DECISION DELEGATED TO DEVELOPMENT MANAGER

Application No: H16-0021-19 **Applicant:** C Edgeley

Proposal: Proposed internal alterations and ground floor side extension - approved under H16-0535-14. Amendments to materials used for extension

Location: Bellevue Farm Elm Lane Spalding

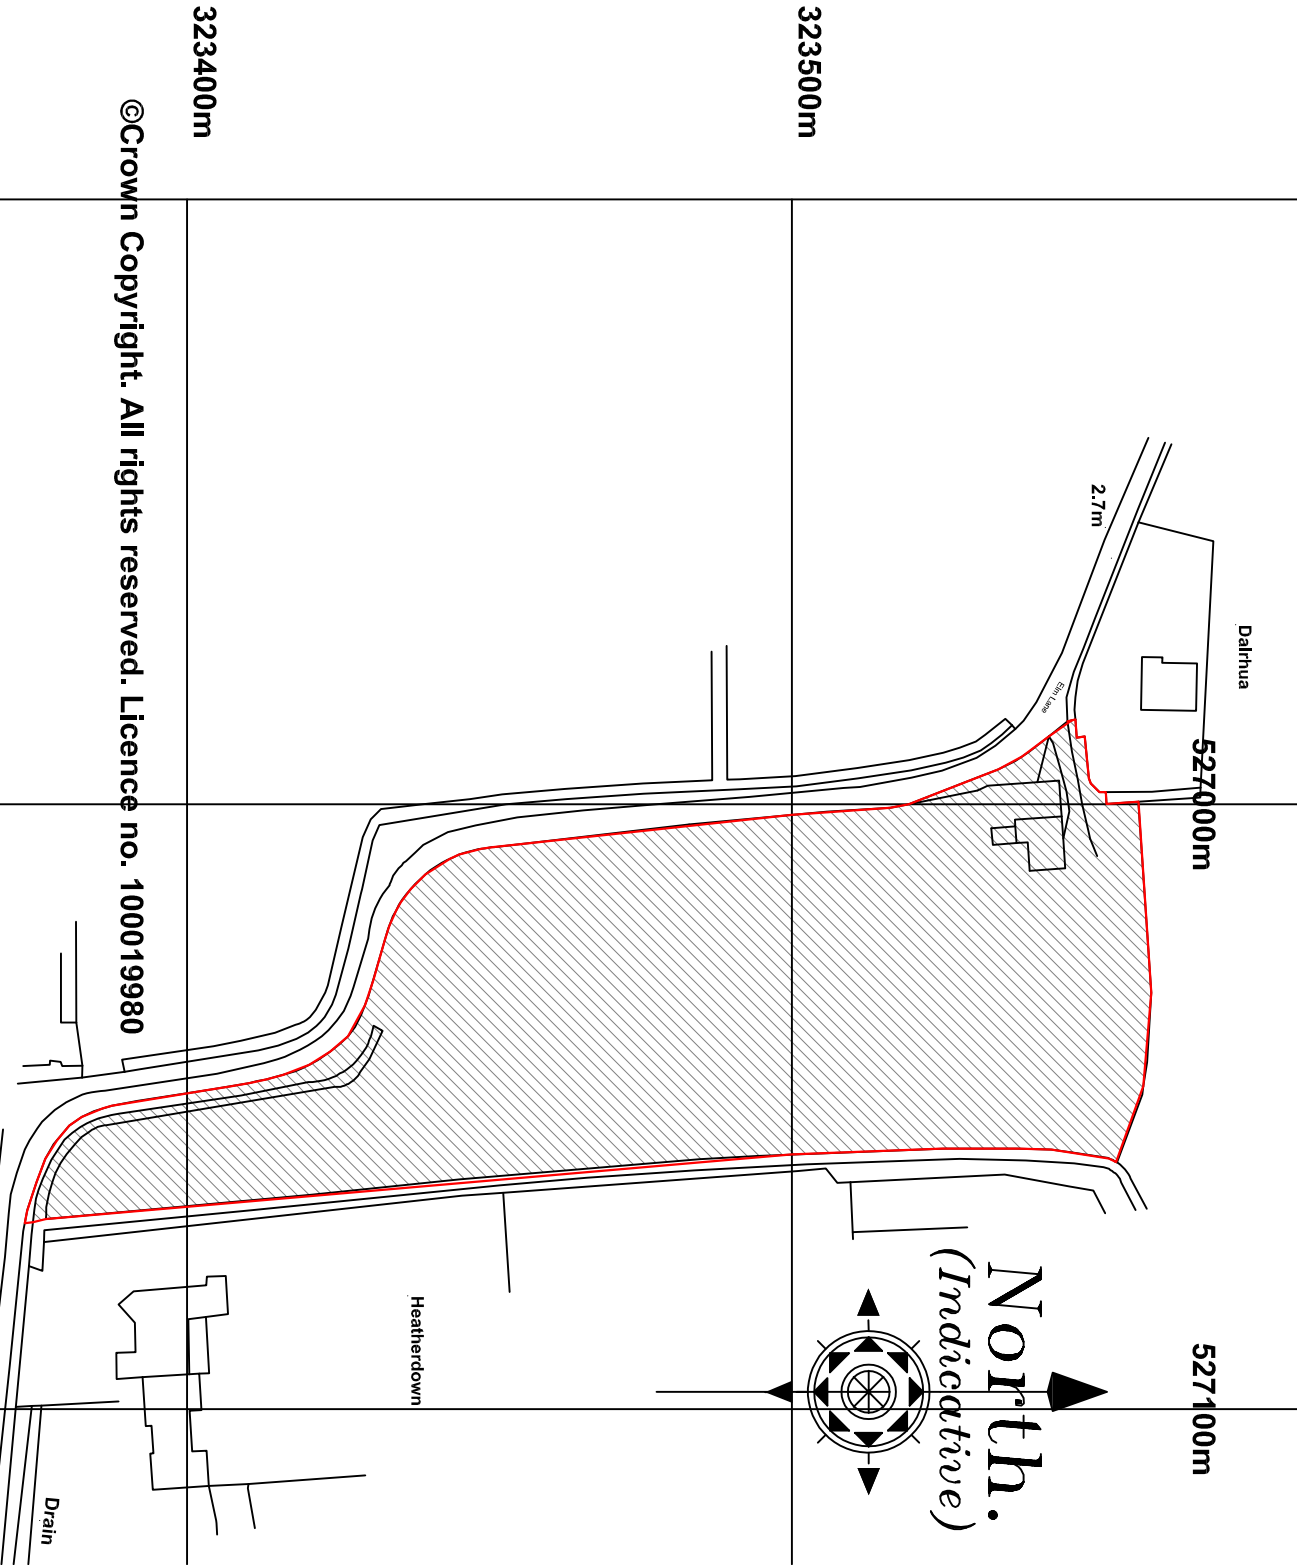
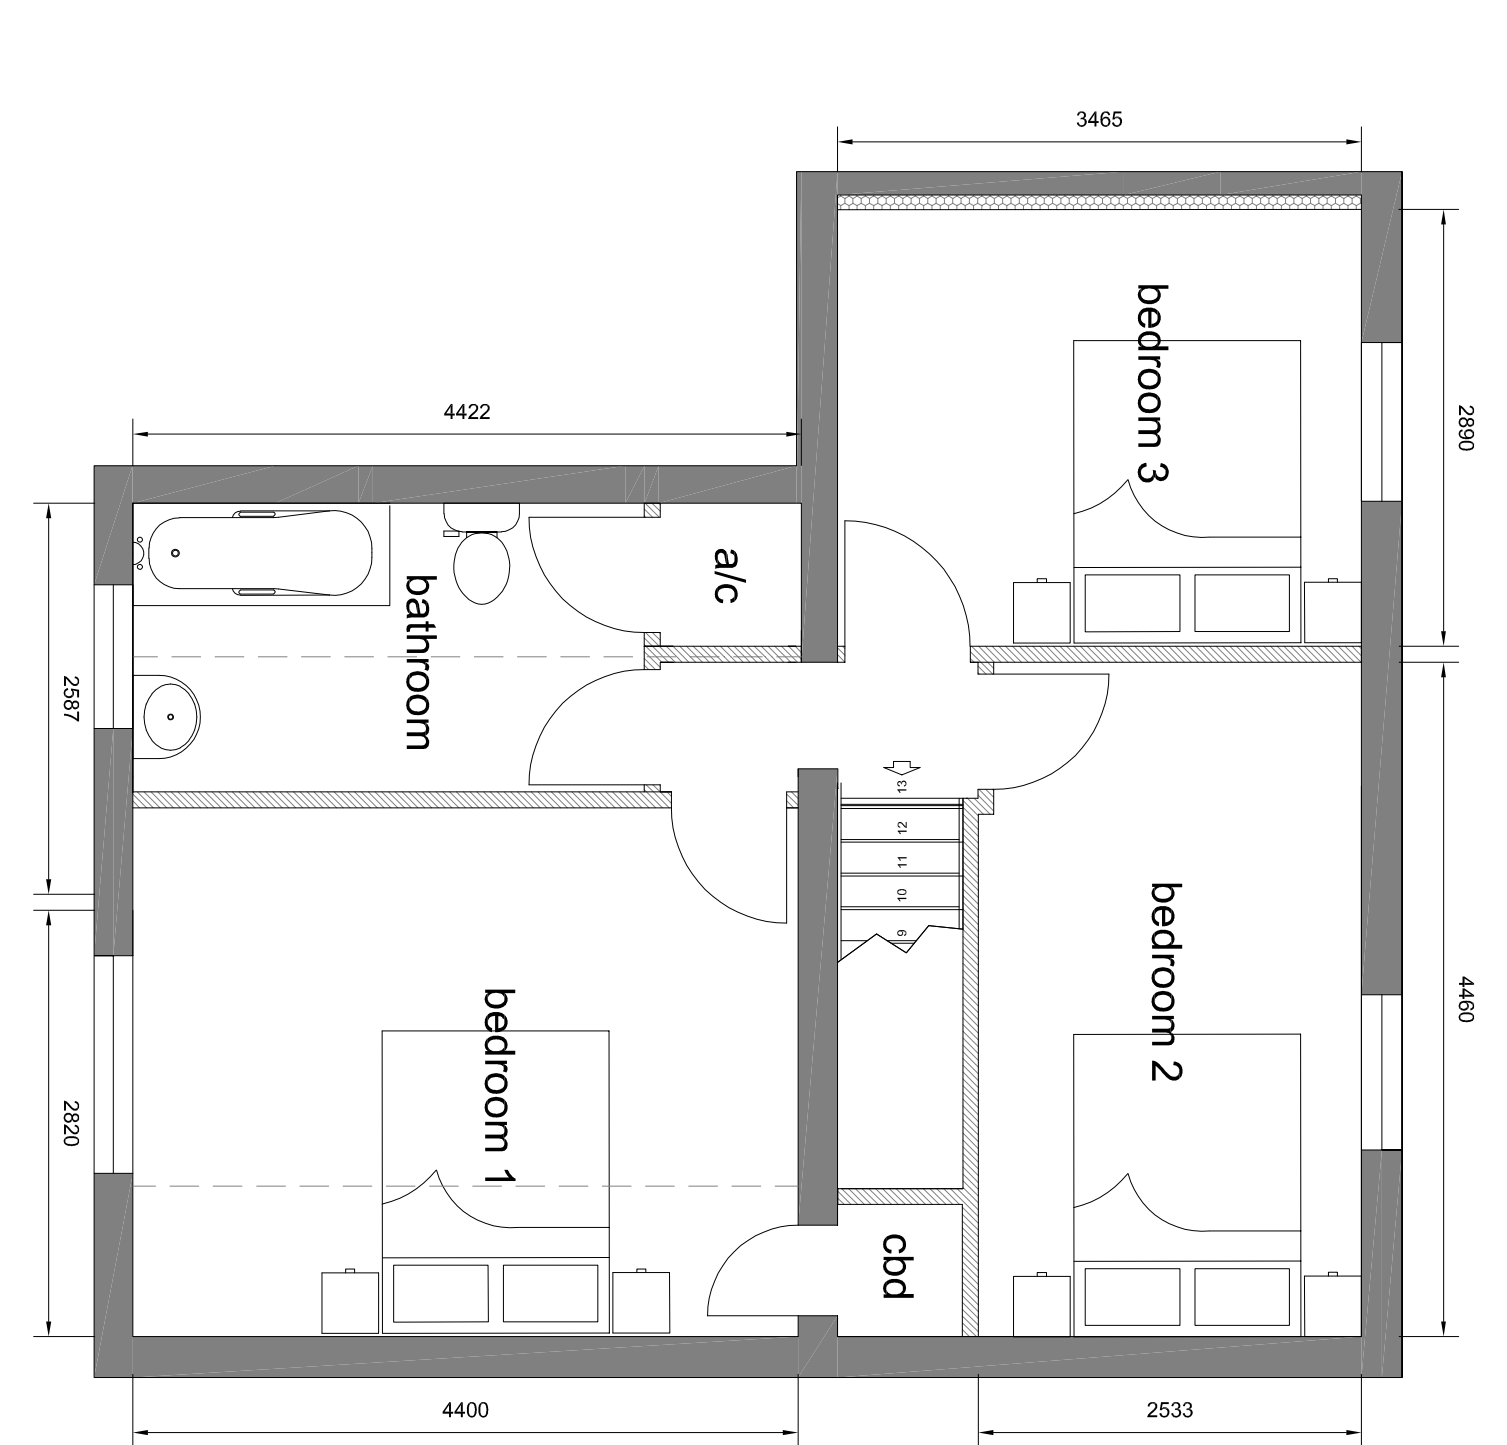
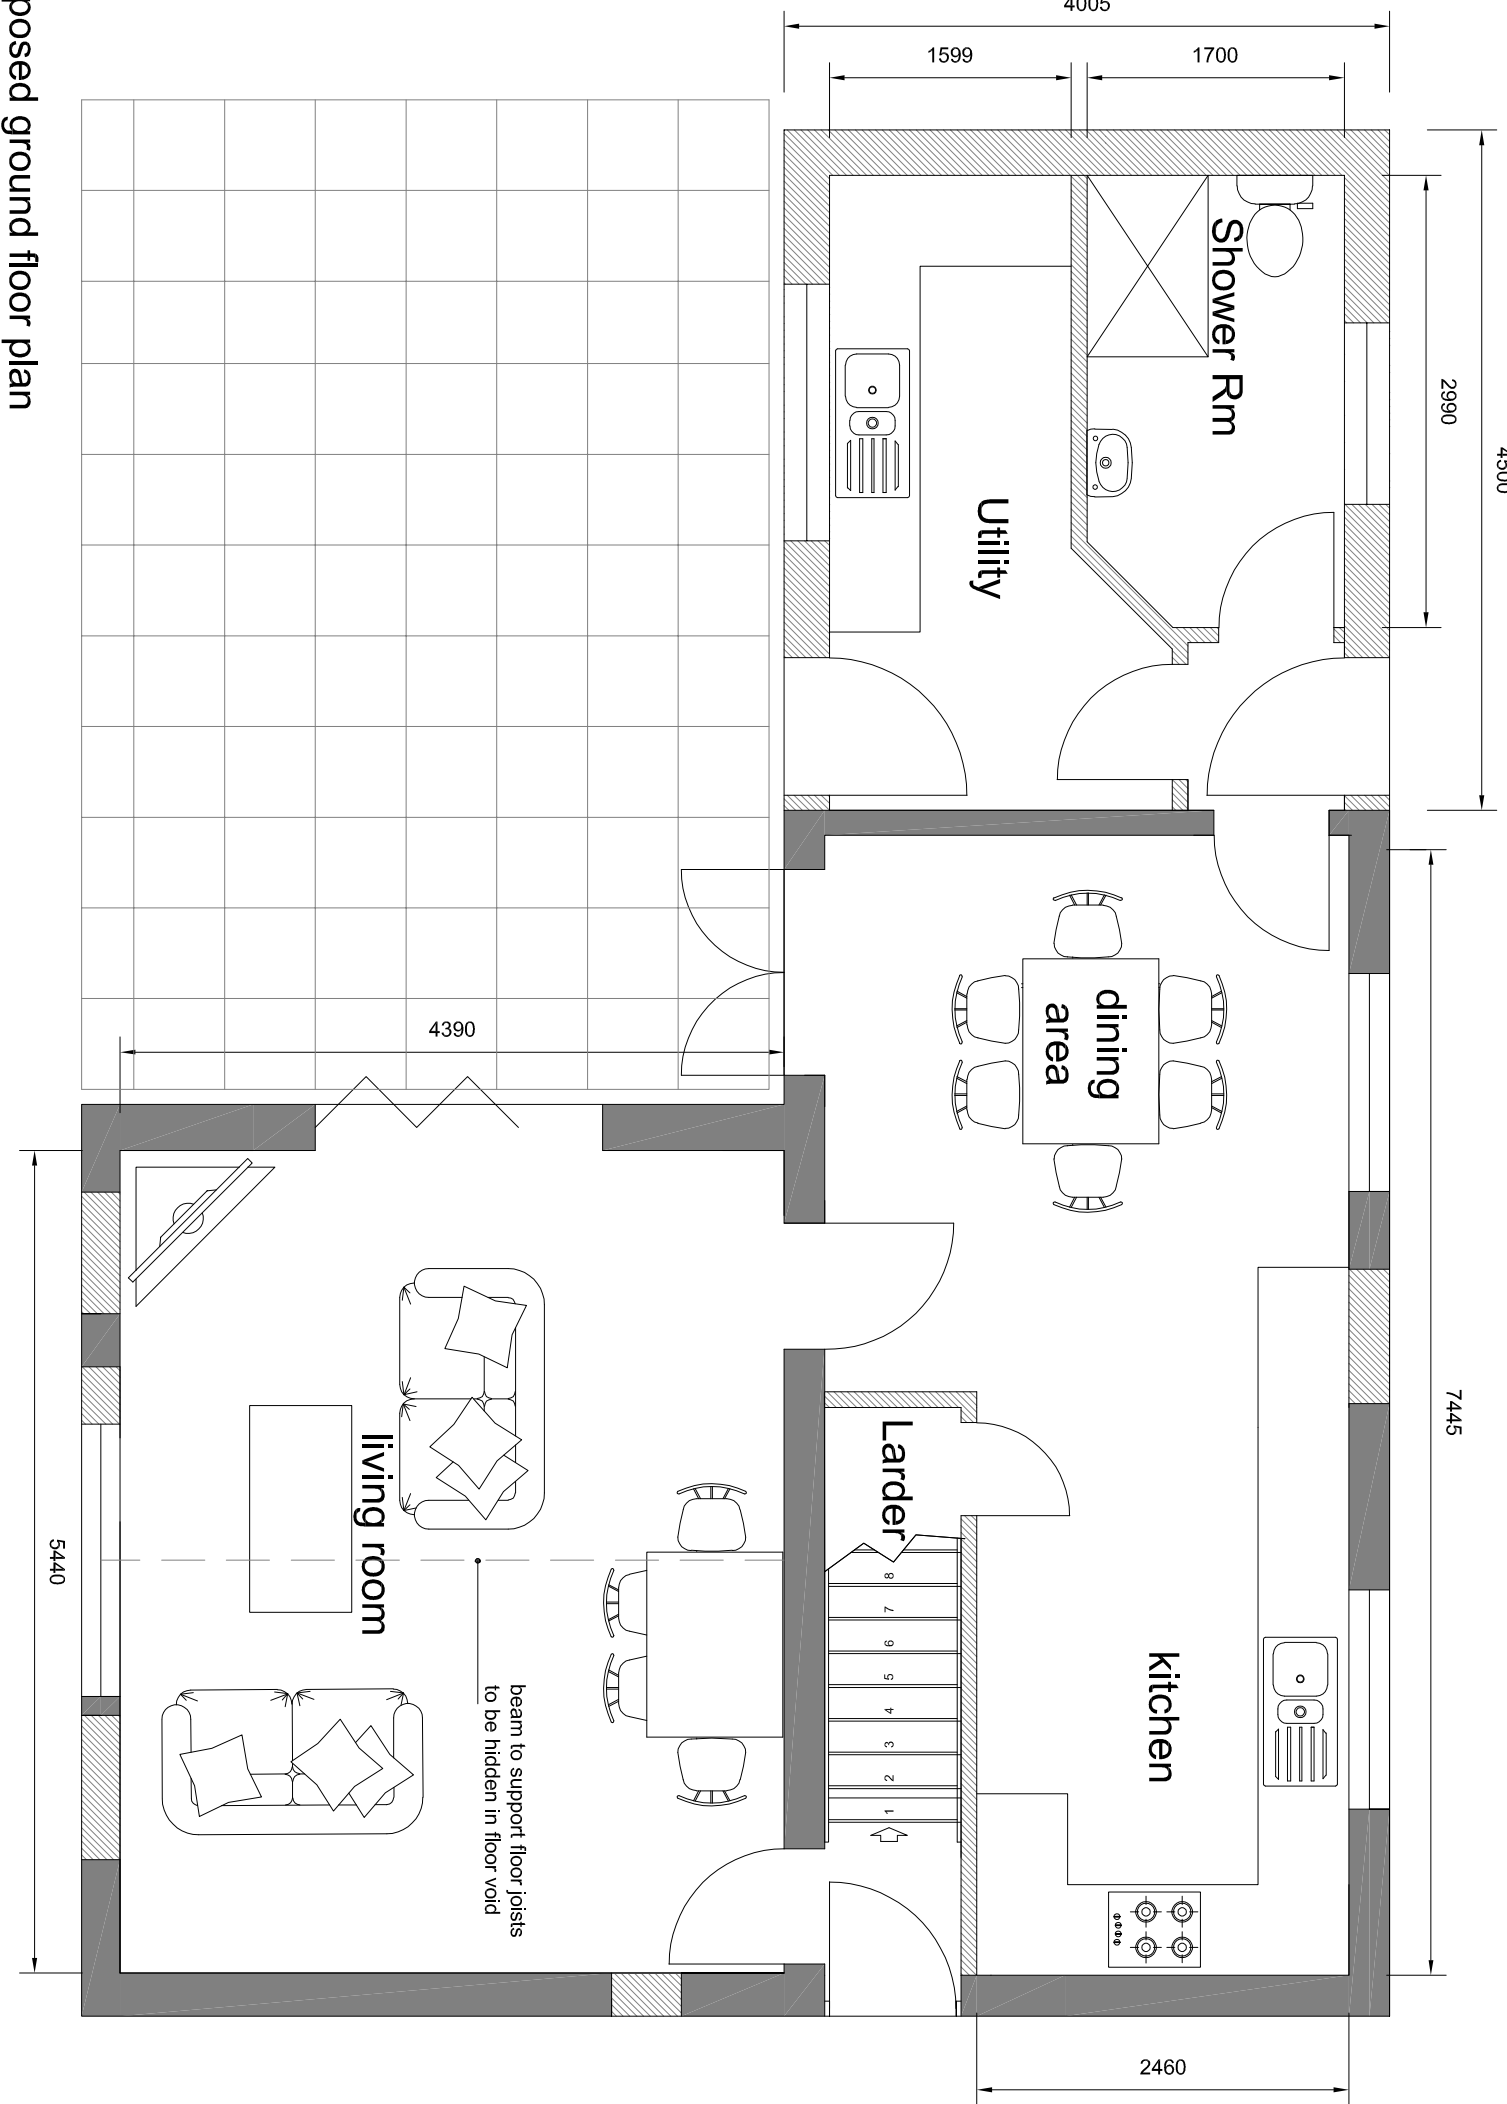
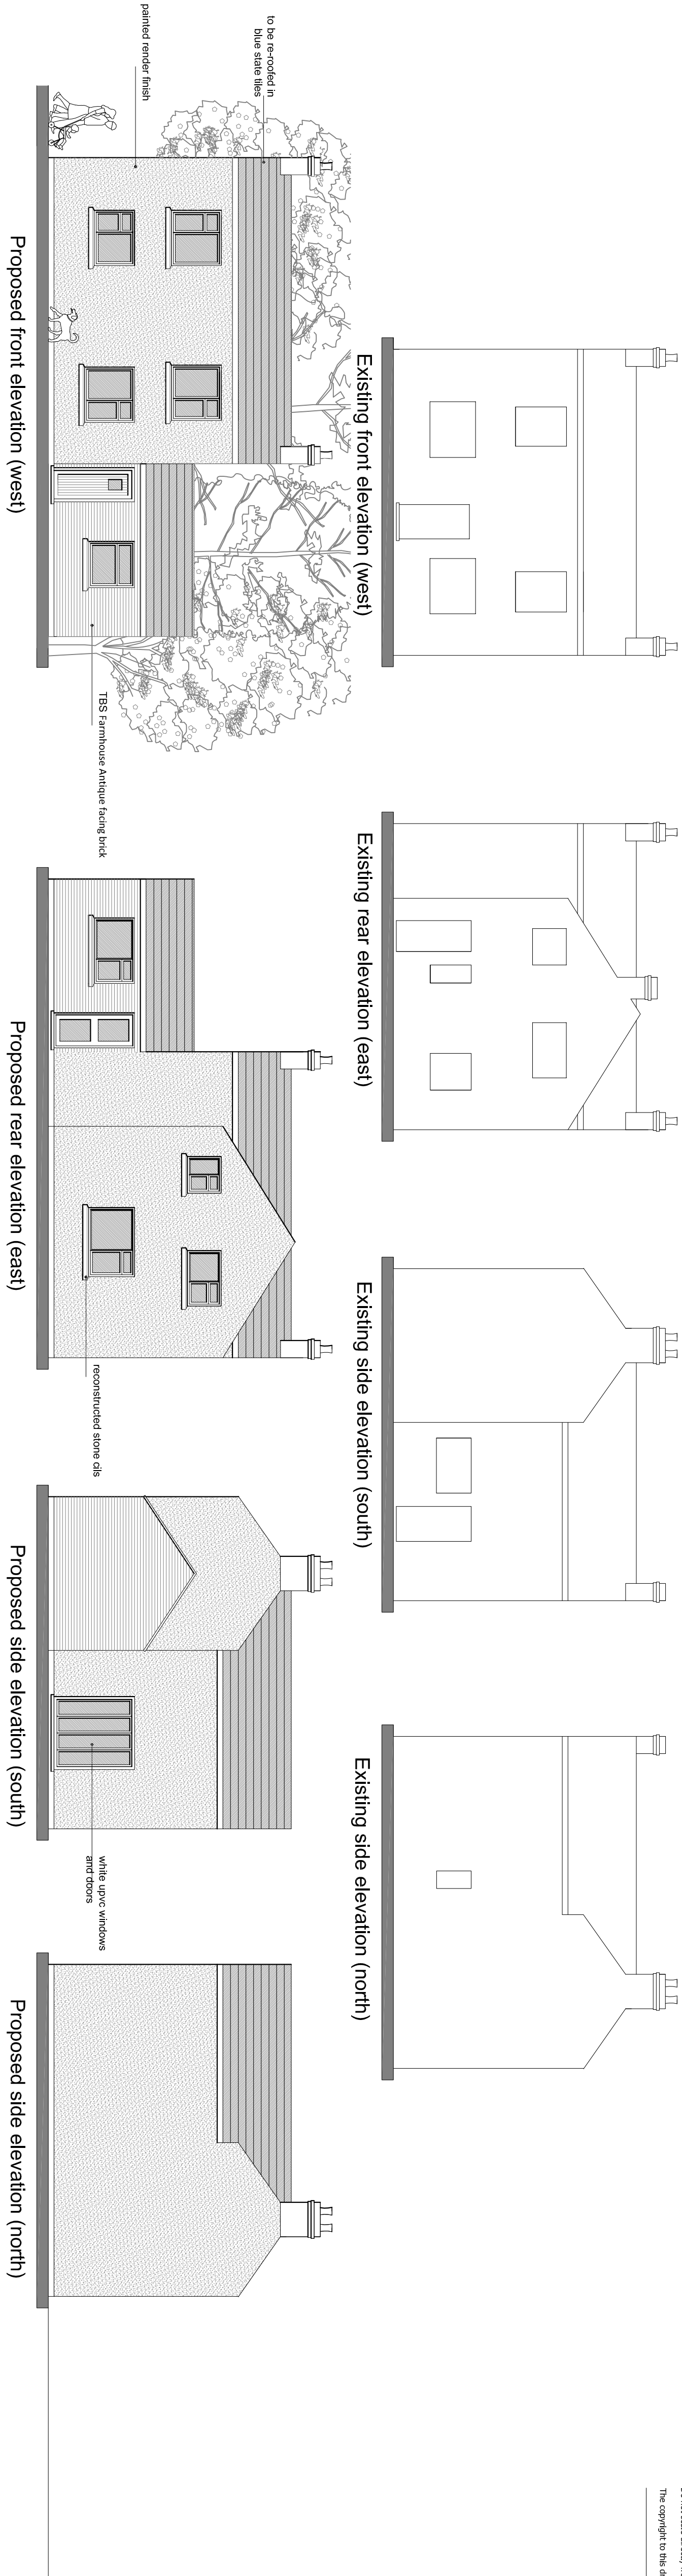
The approved development proposed painted render finish on external insulation of the extension. This application seeks the permission replacement of render for TBS farmhouse antique facing brickwork.

After checking carefully the officer's site photographs of the recent householder application ref. H16-0987-18, it is confirmed that the side extension is currently showing proposed facing brickwork. The applicant confirmed under request that the development was carried out before 25 June 2017. Such material match the masonry of the original dwelling in colour and type. No harm upon the visual amenity has been observed.

The change in materials is considered to satisfy criteria for a non-material amendment and is acceptable.
